Re: **DEL TACO**
1500 Gibson Blvd SE
Traffic Circulation Layout
Architect's Stamp 10-12-2021 (L15-D049)

Based upon the information provided in your submittal received 11-12-2021, the above referenced plan cannot be approved for Building Permit until the following comments are addressed:

☐ BUILDING PERMIT APPROVAL
☐ CERTIFICATE OF OCCUPANCY

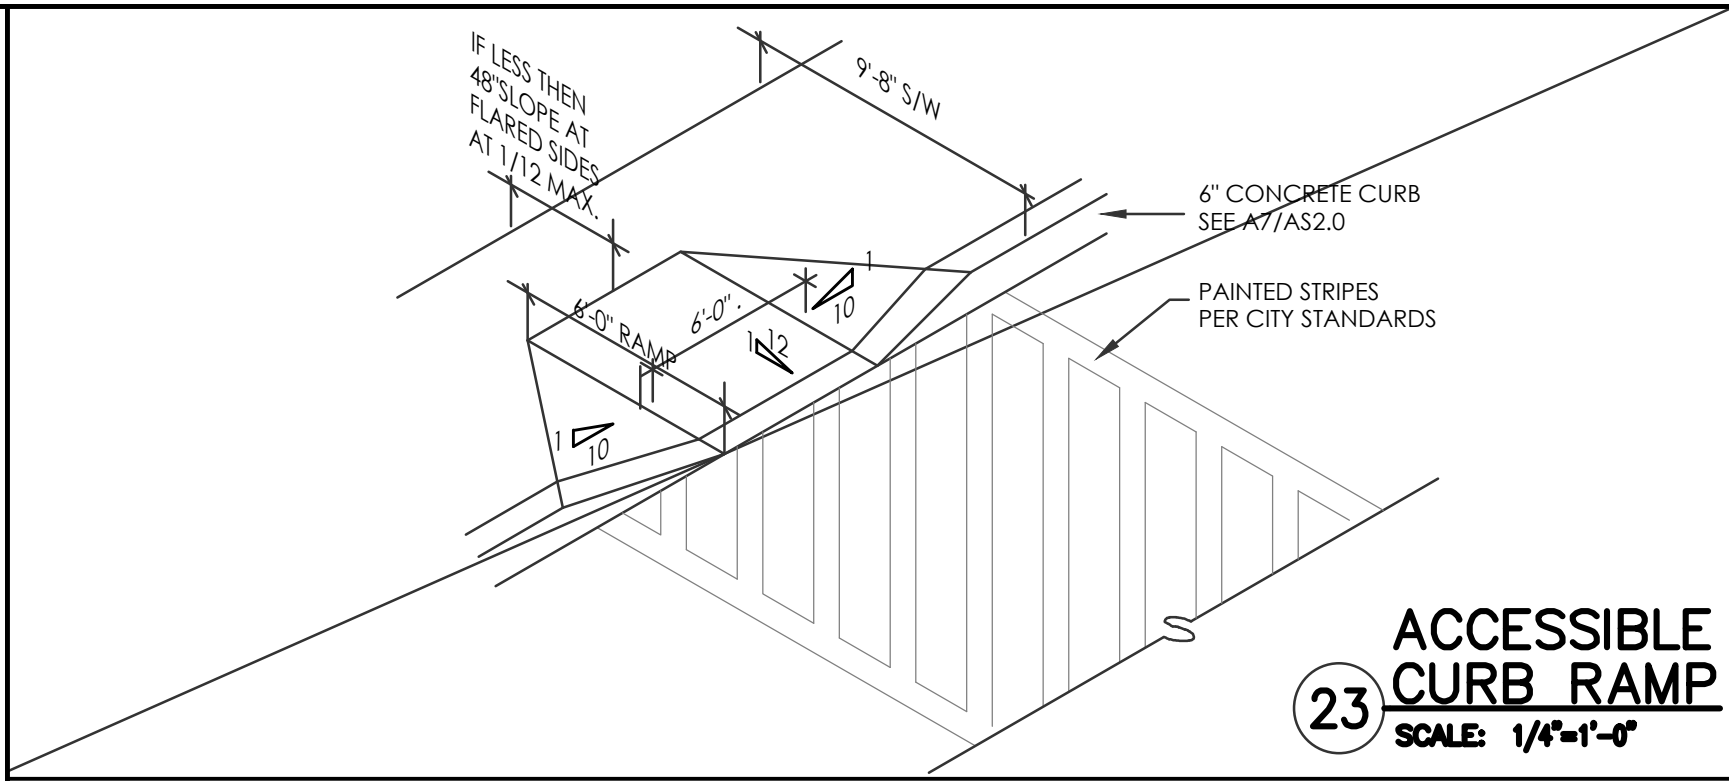
1. Provide existing and proposed sidewalk width.
2. All proposed pavement markings will need to have details provide
3. Keyed Note 2: Provide the size of proposed c&g (6") since there are several on COA std dwg 2415A.

4. Keyed Note 10 Accessible Ramp: Recommended referencing COA std dwg 2444, especially for the accessible ramps in front of the building entrance.
5. Keyed Note 27 & 36: provide signage's face details.

6. Keyed Note 16: please add not (proposed sign will need to be located on private property which includes air space.
7. Identify all existing access easements and rights of way width dimensions (If applicable).

8. ADA curb ramps must be updated to current standards and have truncated domes installed. Verify that existing Gibson Blvd. driveway entrance ramps are in compliance

9. Provide dimension for Motorcycle parking space.
10. List radii for all curves shown; for passenger vehicles (minimum radius per DPM 15 ft). Radius for delivery trucks, fire trucks, etc. is 25 ft. or larger.

11. Per the IDO, a 6 ft. wide ADA accessible pedestrian pathway is required from the public sidewalk to the building entrances. Please clearly show this pathway and provide details.

12. Per DPM, a 6 ft. wide ADA accessible pedestrian pathway is required from the ADA parking stall access aisles to the building entrances. Please clearly show this pathway and provide details.

13. ADA accessible pedestrian pathway should not be placed behind parking space or adjacent to a vehicular way. Vehicle and pedestrian/wheel chair conflicts should be avoided as much as possible. This is concerning the ADA parking stall access aisle across the main circulation drive aisle

14. Parking areas shall have barriers to prevent vehicles from extending over public sidewalk, public right-of-way, or landscaping.
15. ADA parking stall signage and 2 ft overhang is in conflict. Please clear up.

16. Provide details for "Do Not Enter" signage.
17. **The minimum drive through lane width is 12 feet with a 25 foot minimum radius (inside edge) for all turns. (A 15 foot radius can be used with an increase in lane width to 14 feet). Please dimension all lane widths and radii.**

18. Please provide a sight distance line (SSD) exhibit.
19. Please specify the City Standard Drawing Number when applicable.
20. Shared Site access: driveways that straddle property lines, or are entirely on one property but are to be used by another property, shall have an access easement. Please include a copy of your shared access agreement with the adjacent property owner.

21. Add a note stating "All broken or cracked sidewalk must be replaced with sidewalk and curb & gutter." A build note must be provided referring to the appropriate City Standard drawing (2430 & 2415A). This is the correct note and should be replaced on keyed note 22.
